Application for a non-material amendment following a grant of planning permission.

Number	47
Suffix	
Property name	
Address line 1	Lincoln Avenue
Address line 2	
Address line 3	
Town/city	Aldwick
Postcode	PO21 3EW
Description of site location must be completed if postcode is not known:	
Easting (x)	490379
Northing (y)	99613
Description

TwoStorey side extension, single storey rear Extension and single storey front extension with porch and addition of 2 x front and 1 x rear dormer

Reference number:	AW/200/21/HH
Date of decision	26/08/2021

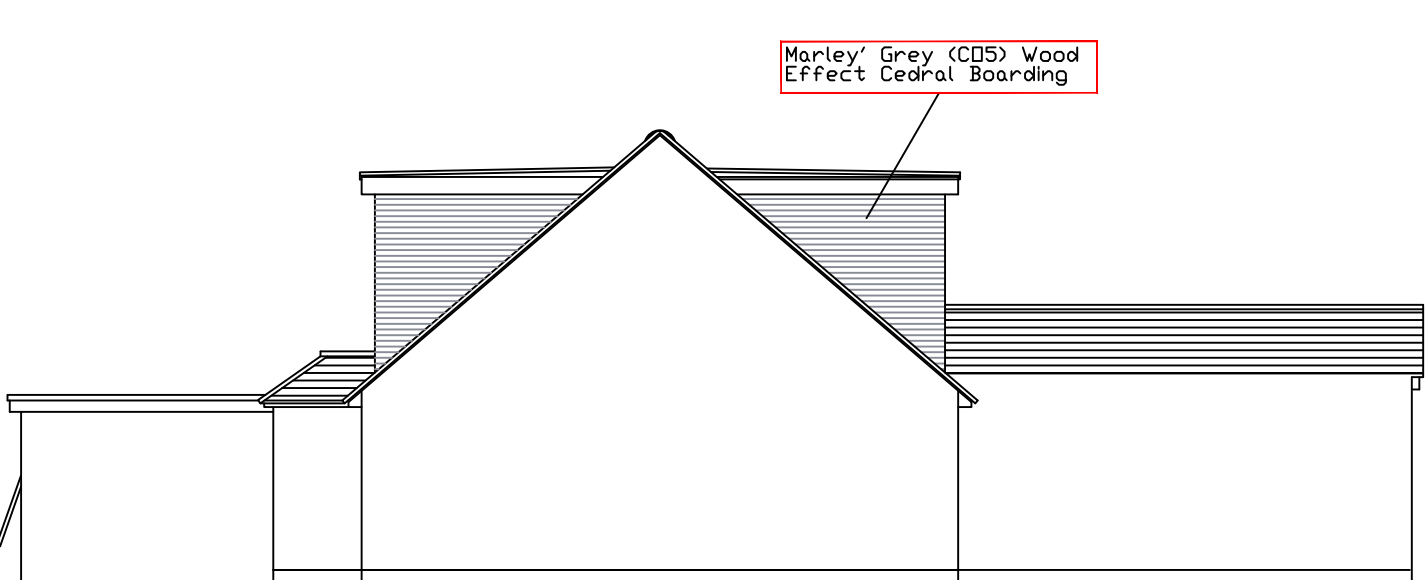
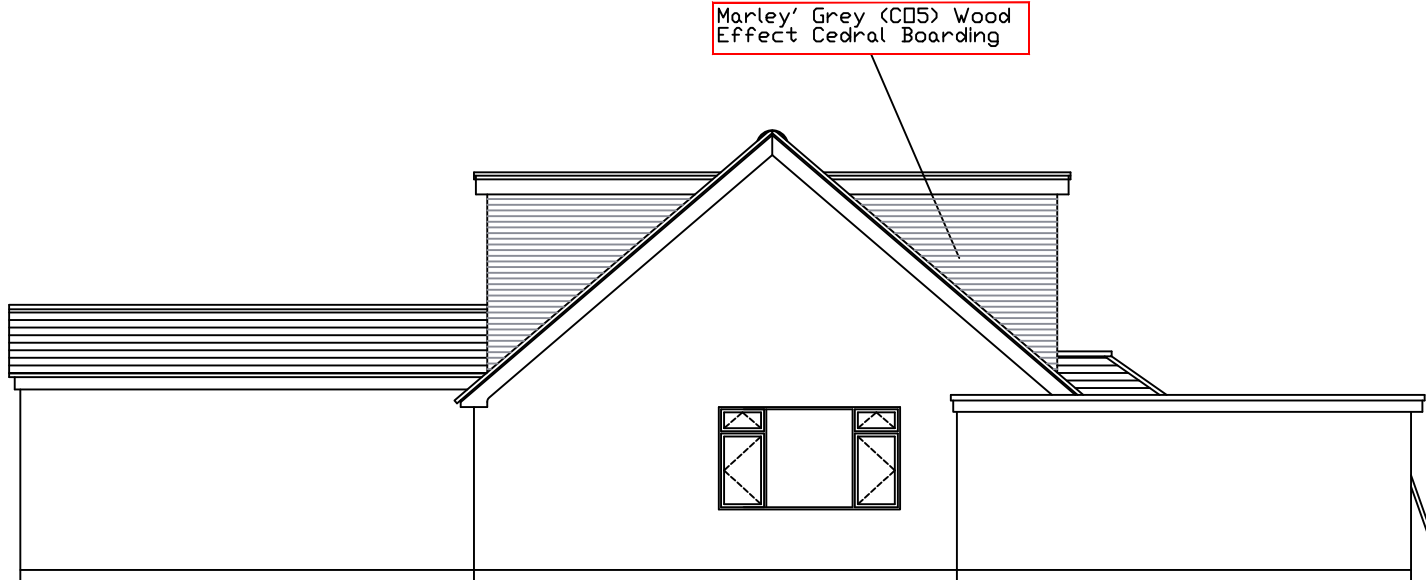
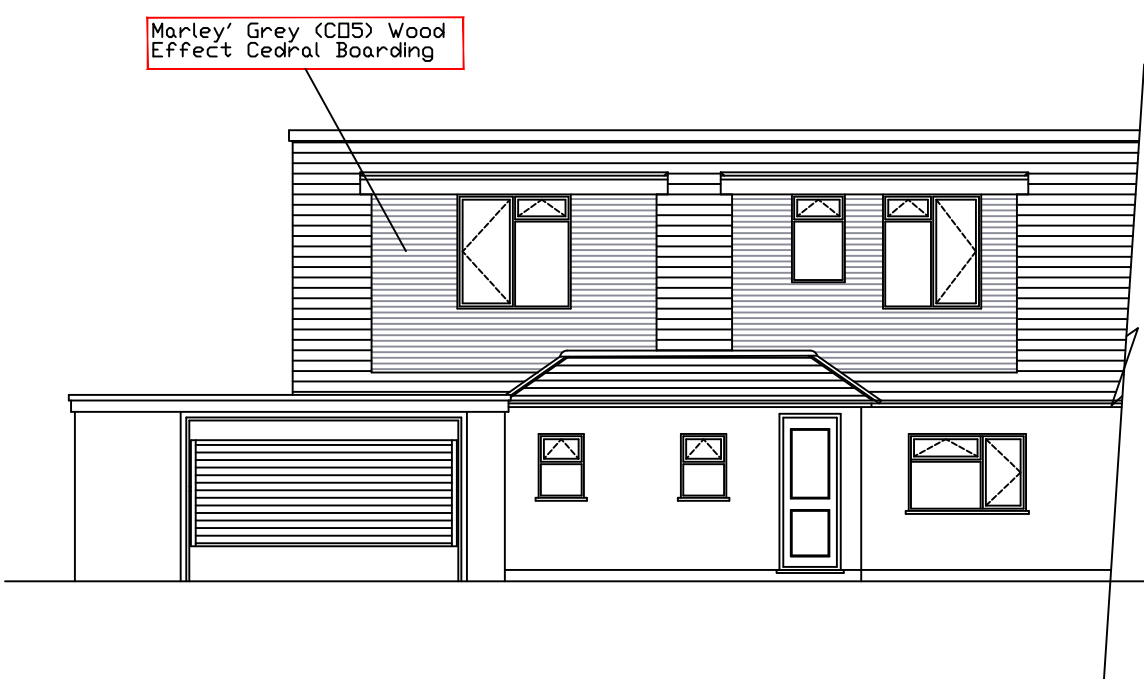
Dormer fronts to sit on Front Wall Plate similar to others in the Road

To correct the Drawings already issued and match others in the same Road
